WEST SUSSEX COUNTY COUNCIL CONSULTATION

TO:	Arun District Council FAO: Mrs A Gardner
FROM:	Highways, WSCC
DATE:	20/09/2018
LOCATION:	46a and 46b Pier Road, Littlehampton, BN17 5LW
SUBJECT:	LU/182/18/PL Demolition of the existing buildings and erection of 2 No. new buildings incorporating commercial (A1) at ground floor with 4 No. new residential units above.
DATE OF SITE VISIT:	20/09/2018
RECOMMENDATION:	☐ Advice ☐ Objection ☐ Modification ☐ No Objection ☒ More Information ☐ Refusal
S106 CONTRIBUTION TOTAL:	£N/A

drawing **Proposed site plan**

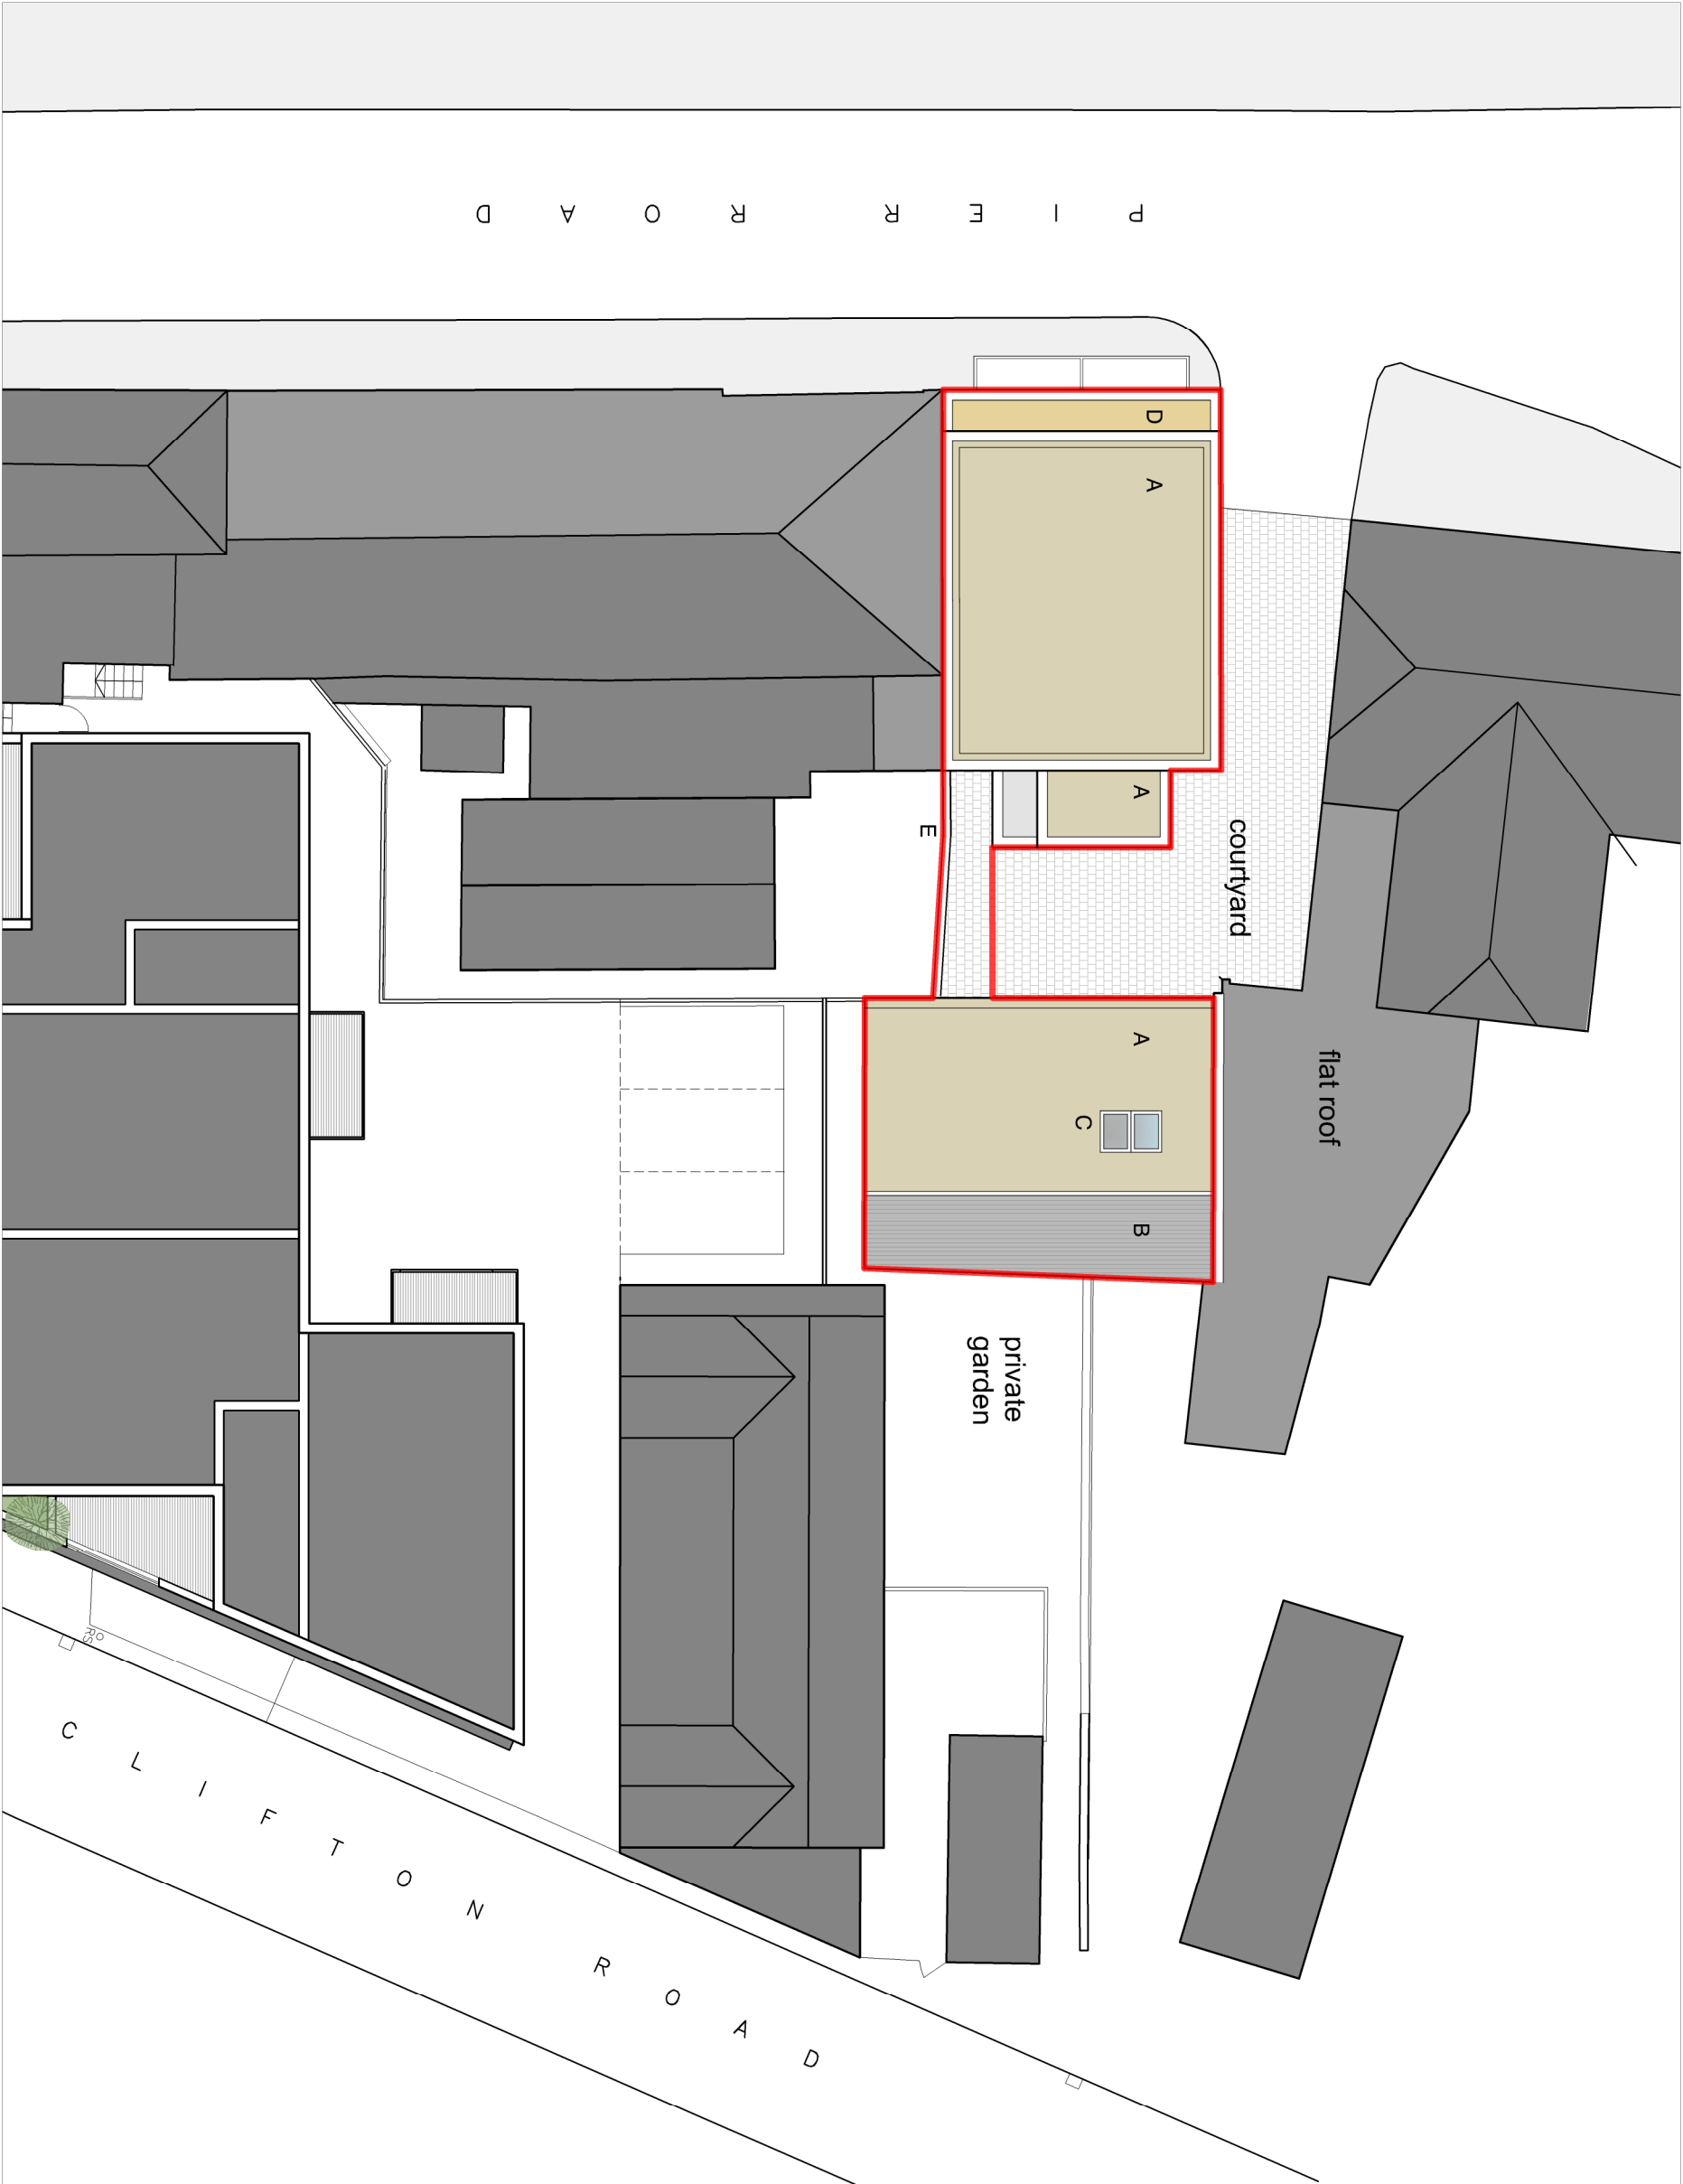
The applicant proposes to provide three covered parking spaces for the residential use. The applicant is requested to provide swept path tracking in order to demonstrate that vehicles can manoeuvre in and out of the proposed spaces and turn on site in order to exit onto the public highway in a forward gear.

Covered cycle storage has been demonstrated within the car port area, although the applicant may wish to consider the practicality of the proposed location in terms of accessibility should three vehicles be parked at the same time.
